Planning Inspectorate

Case ref: EN010158

Application by Rosefield Energyfarm Limited for an order granting development consent for the Rosefield Solar Farm

Advice following issue of decision to accept the application for examination

KEY:

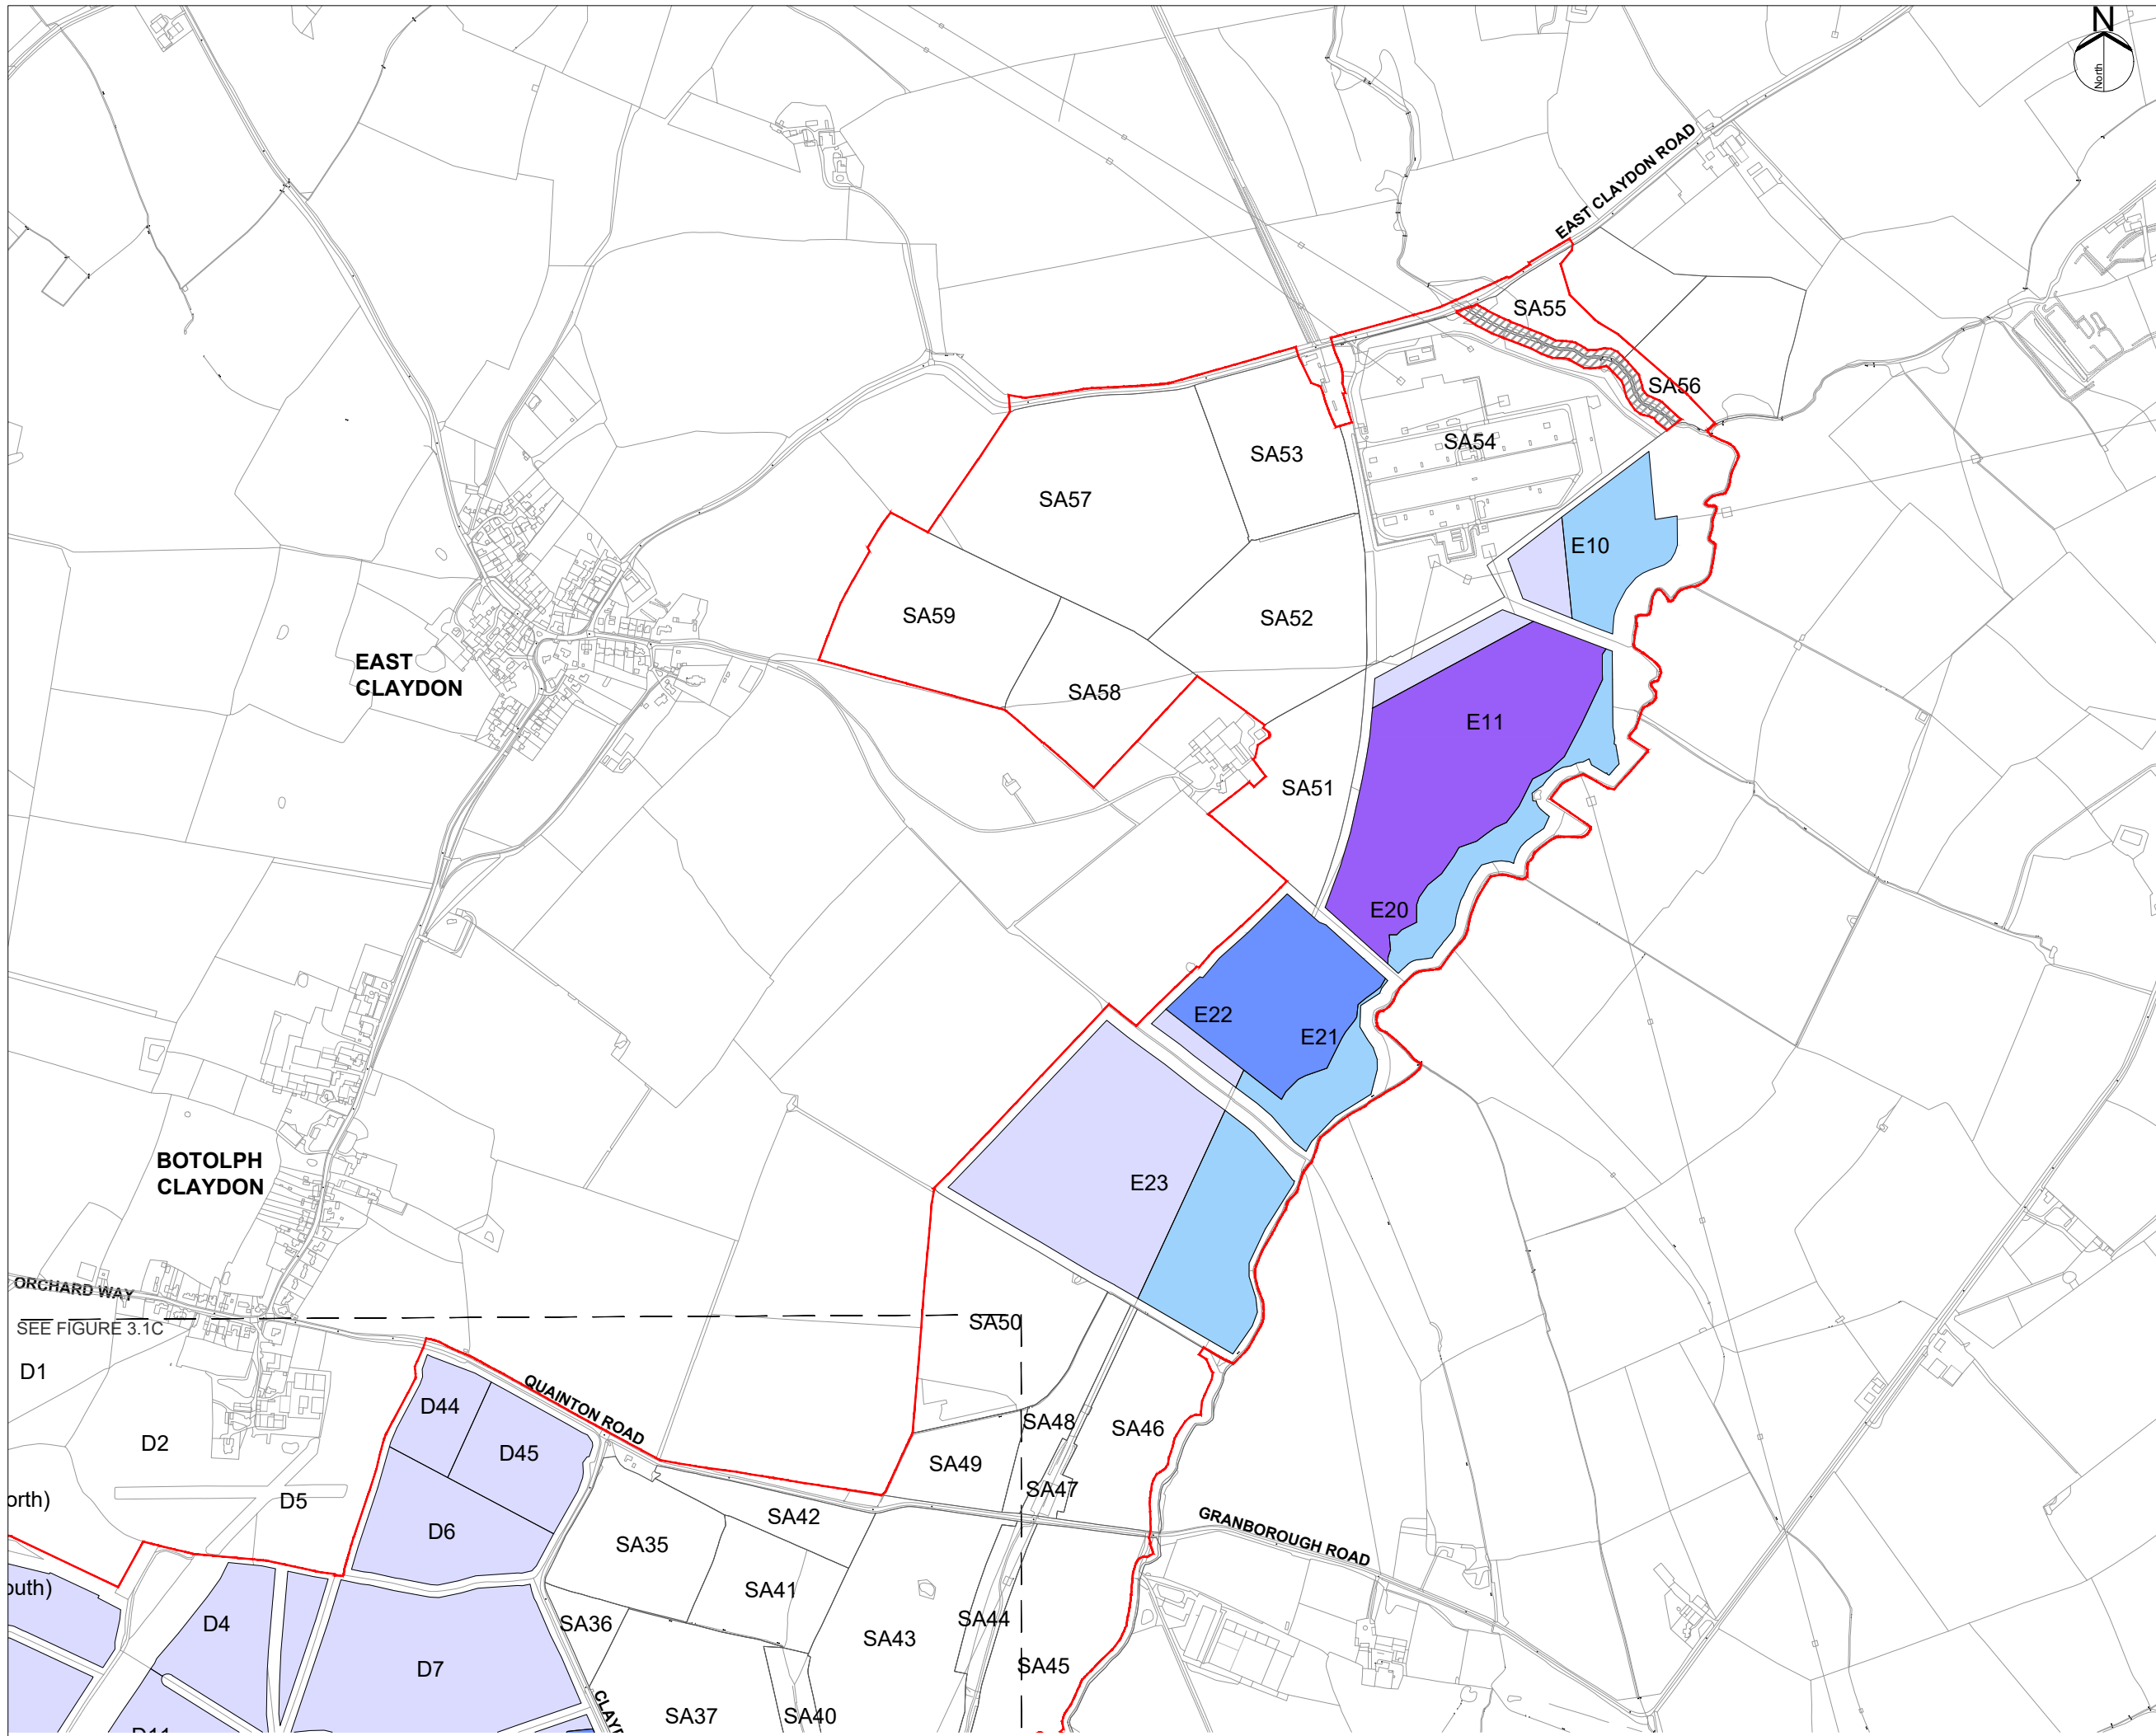
It is difficult to differentiate between ALC grades as presented in **Volume Chapter 12: Soil Figure 12.1** (Doc. 6.3) due to the shading used. Similarly, the shading applied in Volume 3 Chapter 3: Proposed Development Description Figures 3.1A – 3.1D makes it difficult to distinguish between proposed development heights of up to 6m from those of up to 15m. Please update the plans accordingly.
